Response to RETROSPECTIVE planning application for amended turning circle and refuse bin collection point for Planning Application No:3/2022/0115

Planning Application No: 3/2017/0920
Grid Ref: 373069 441623
Proposal: Revised application for five town-houses following outline approval 3/2015/0312 including garage block on St Pauls Terrace.
Location: Back St Pauls Street Low Moor Clitheroe BB7 2LS

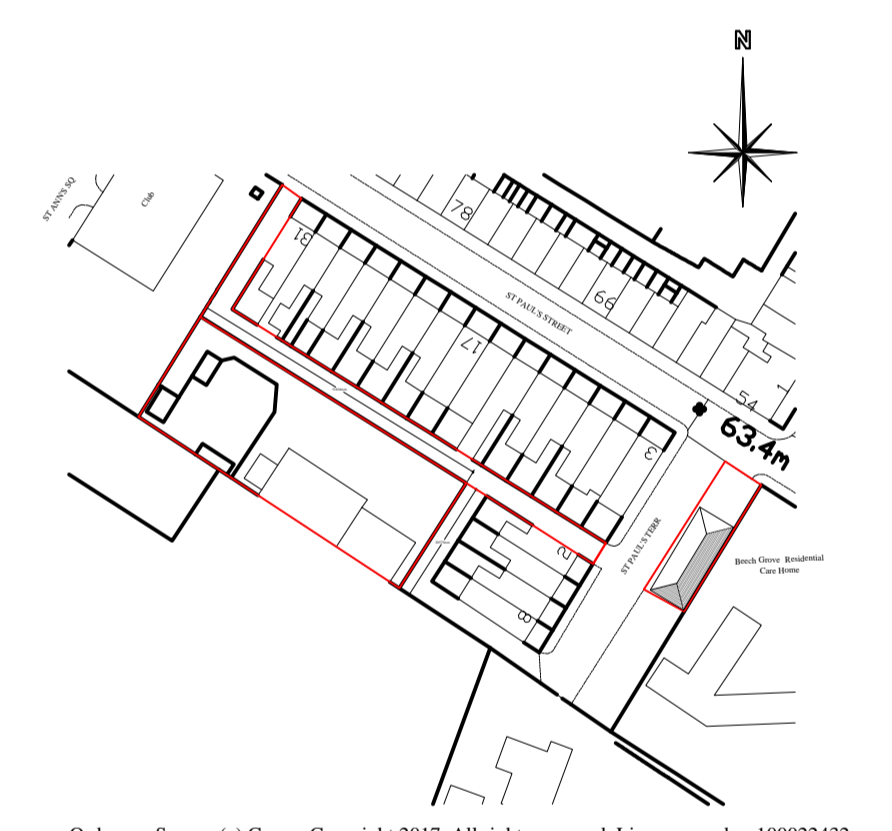
- [REDACTED] Now the turning circle amounts to little more than a small lay-by which will not provide adequate turning for large service or emergency vehicles.

- This back street is the new houses ONLY access for their residents and any deliveries. Most delivery, service and large vehicles will need to reverse to exit via St Paul's terrace unless the turning circle is restored.

In the light of these observations I hope that you insist that the original plan for the turning circle is followed to the letter and take the safety of all to be the determining factor.
